Department of Primary Industries

Woodlawn Bioreactor Site Modification (MP 10_0012 Mod 1 and DA Q91/00233 Mod 2)

Comment by DPI Water

DPI Water has reviewed the proposed modification to the Woodlawn Bioreactor site and provides the following comments:

Figure 2 – Woodlawn ED3 North system

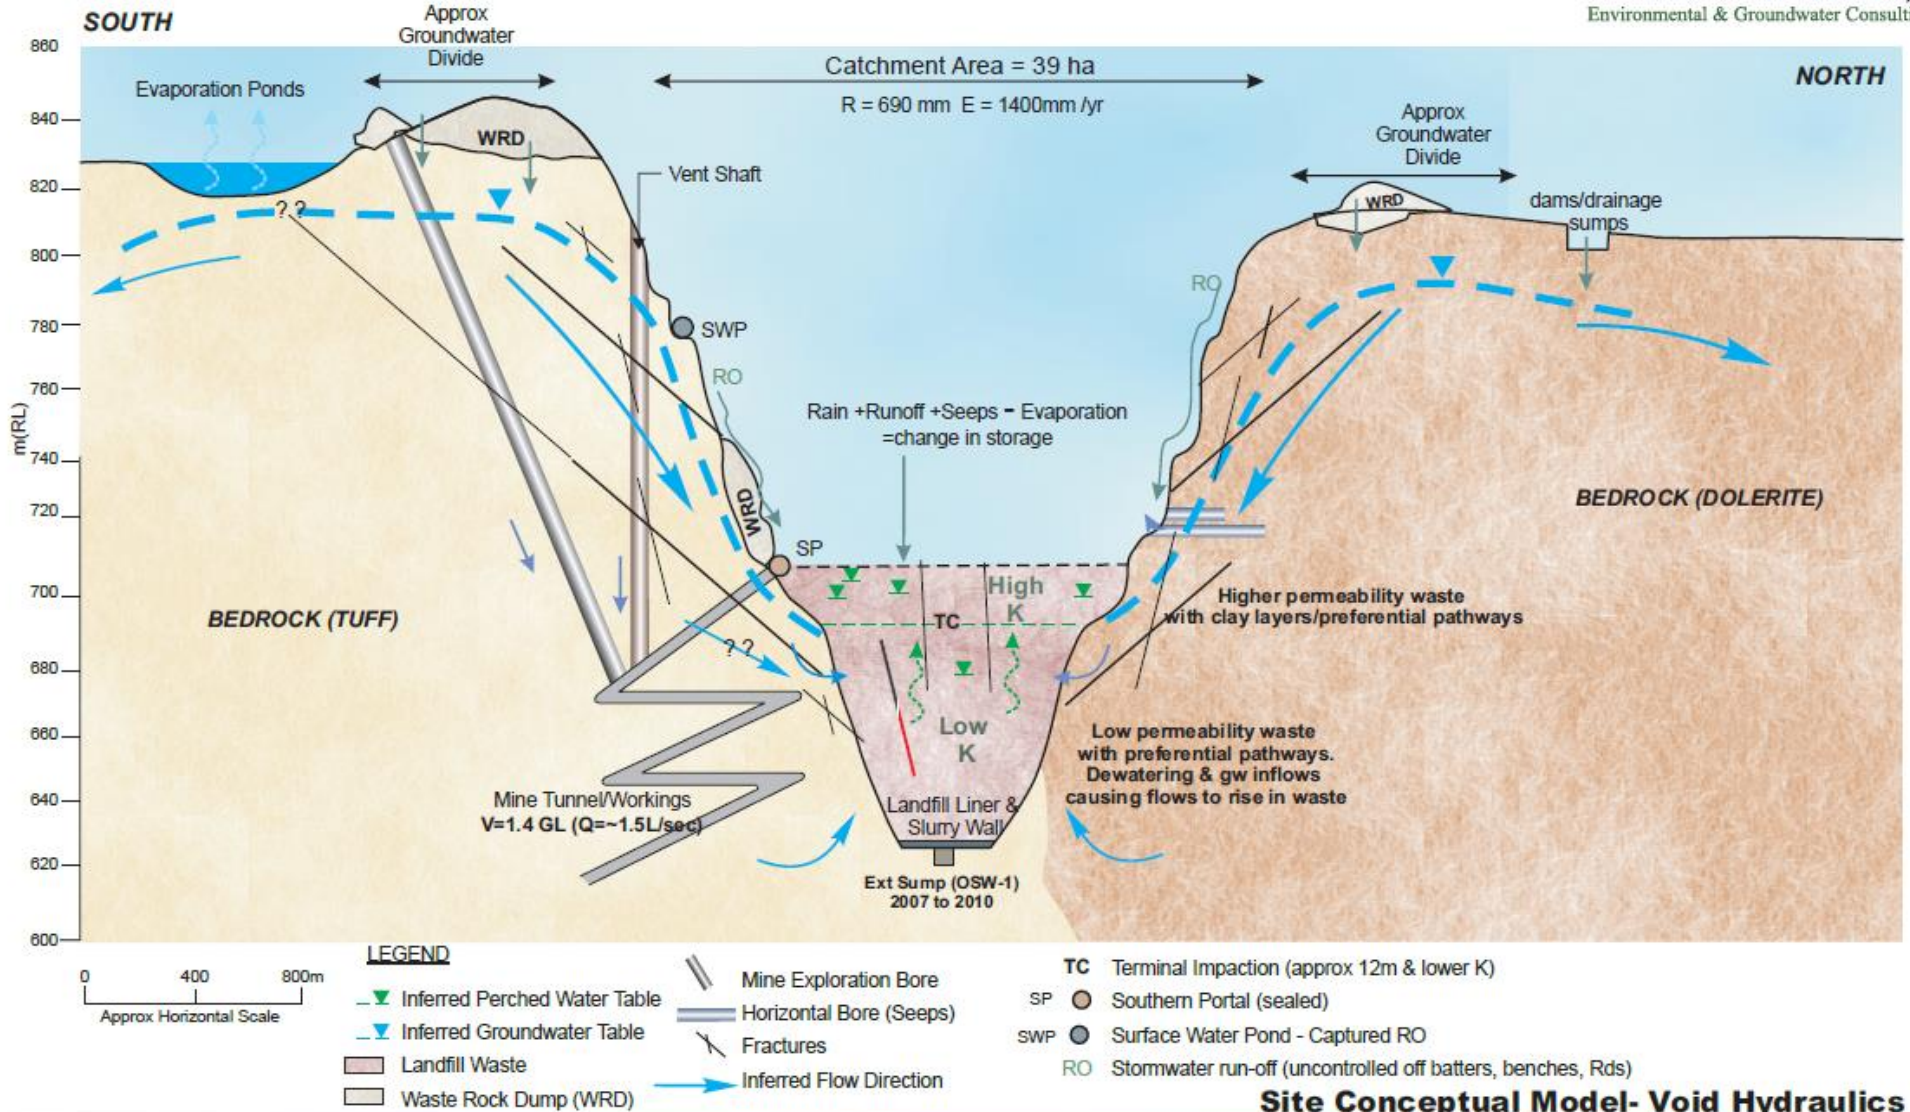
- The proposed modification to the use of existing ponds for the management of leachate under Section 75W of the EP&A Act does not require a Works and Use Approval under the Water Management Act 2000.
- ED3S evaporation dam is to be lined appropriately to limit any potential contamination of groundwater or surface water sources.
- The proposed modification to the use of existing evaporation dams ED2 and ED3S is unlikely to result in any further significant impact to surrounding surface and groundwater sources.
